Letter No. **B2/2655/2000**

Sub: CMDA - Area Plans Unit - Planning Permission -
Proposed construction of GF+3Floor residential
building with 16 dwelling units at T.S.No.4/75,
Block No.45 of Puliyur Village in Plot No.11,
Rathinammal Street, Kodambakkam, Chennai-24 -
Development Charges Advice sent - Regarding.

B.S.P.E. BLDG/144/2000  
 Planning Permit No.  
**APPROVED**  
 SUBJECT TO THE CONDITIONS IN  
 THIS OFFICE LETTER.  
 No. B/1455/2000 Dated 06/12/00  
 FOR MEMBER SECRETARY  
 CHENNAI METROPOLITAN  
 DEVELOPMENT AUTHORITY  
 CHENNAI-600 009.

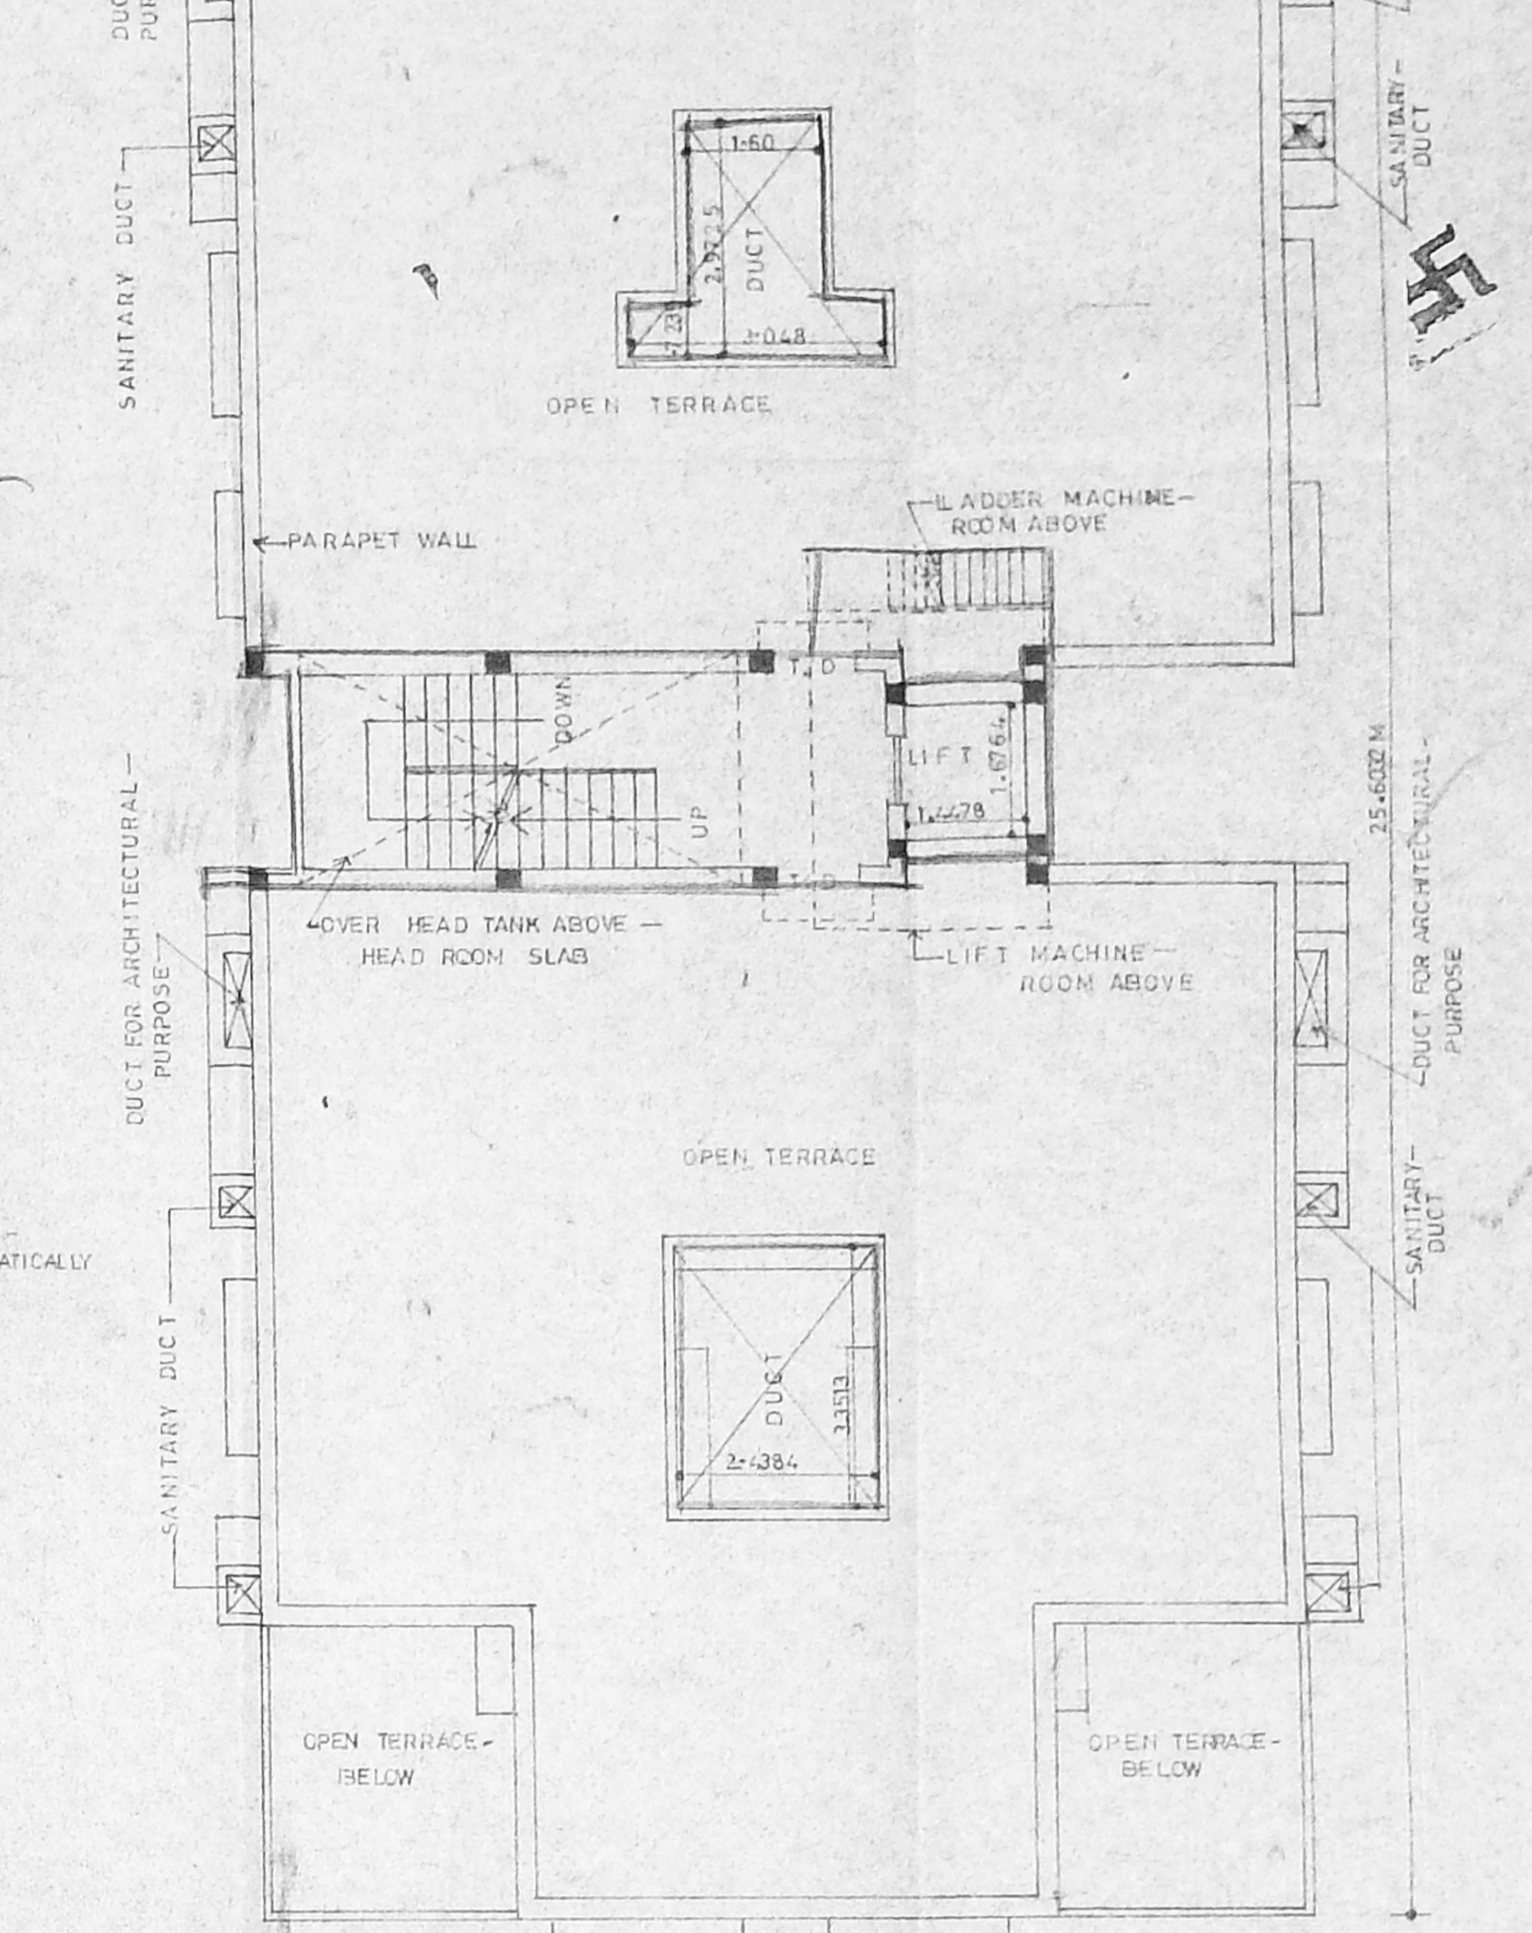
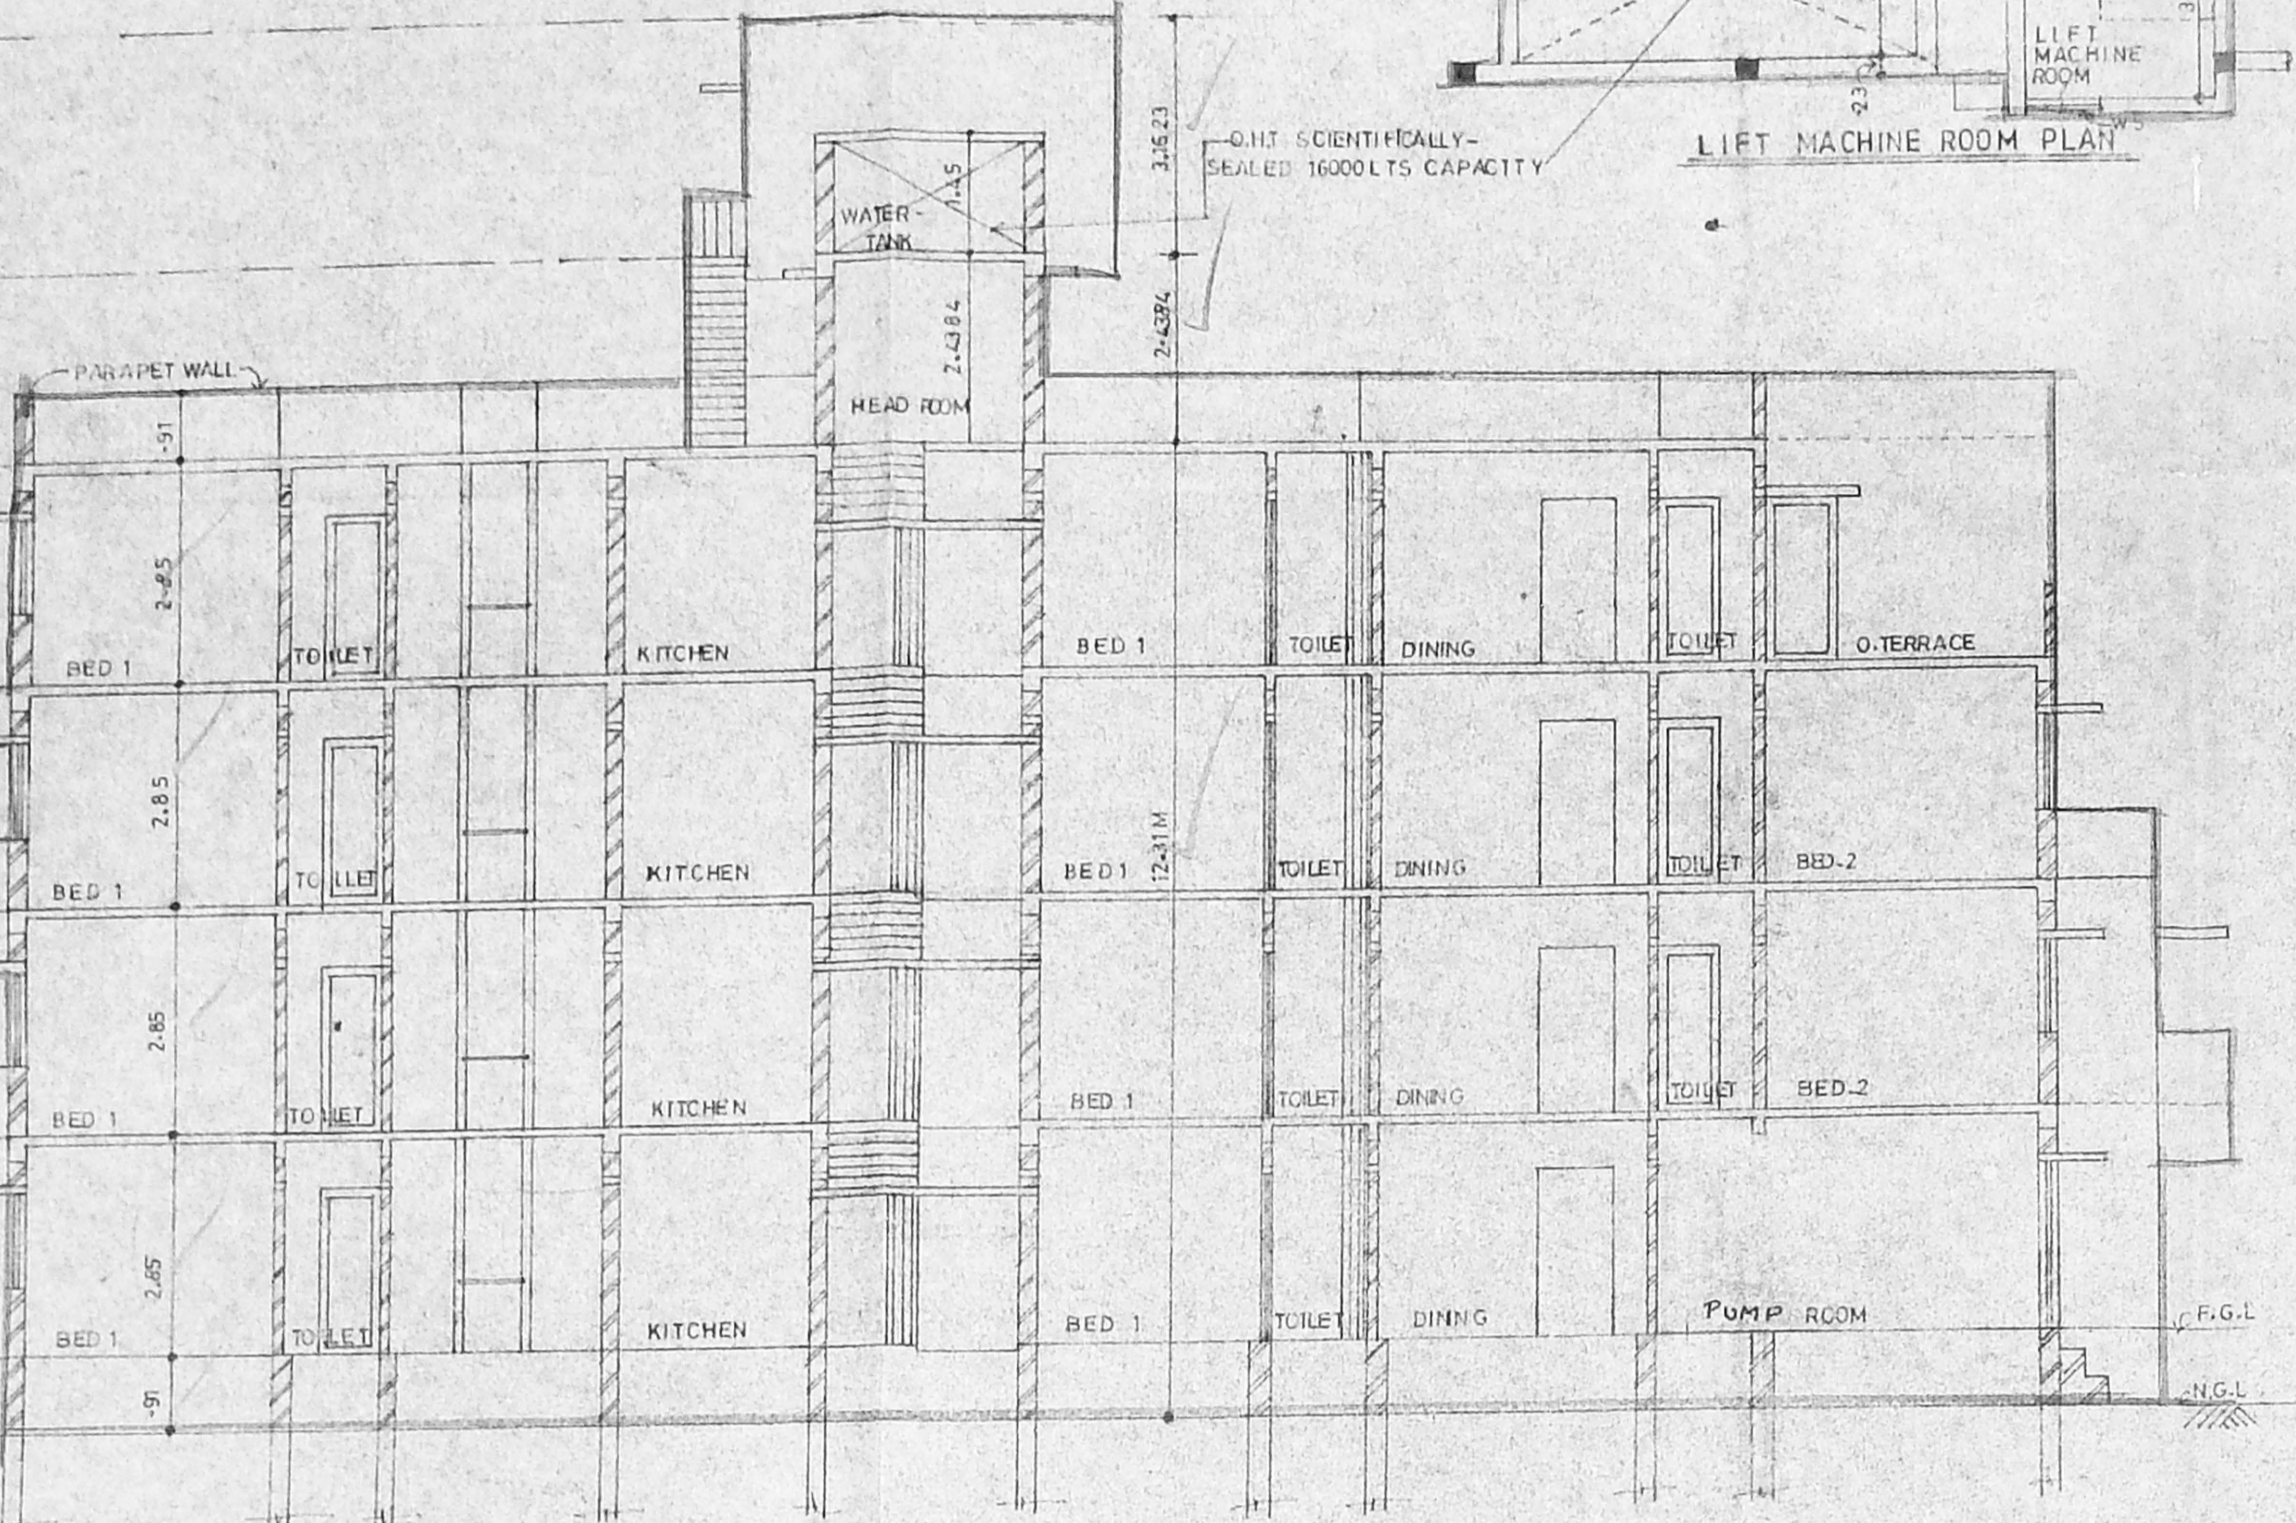
(***) 1.2) Revised plan rectifying the following defects:-

- a) Mention the low terrace portion in 2nd floor plan and 3rd floor plan.
- b) Licensed Surveyor signature in the plan.
- c) Marking the car parking lots in the site plan in confirming with Development Control Rules.
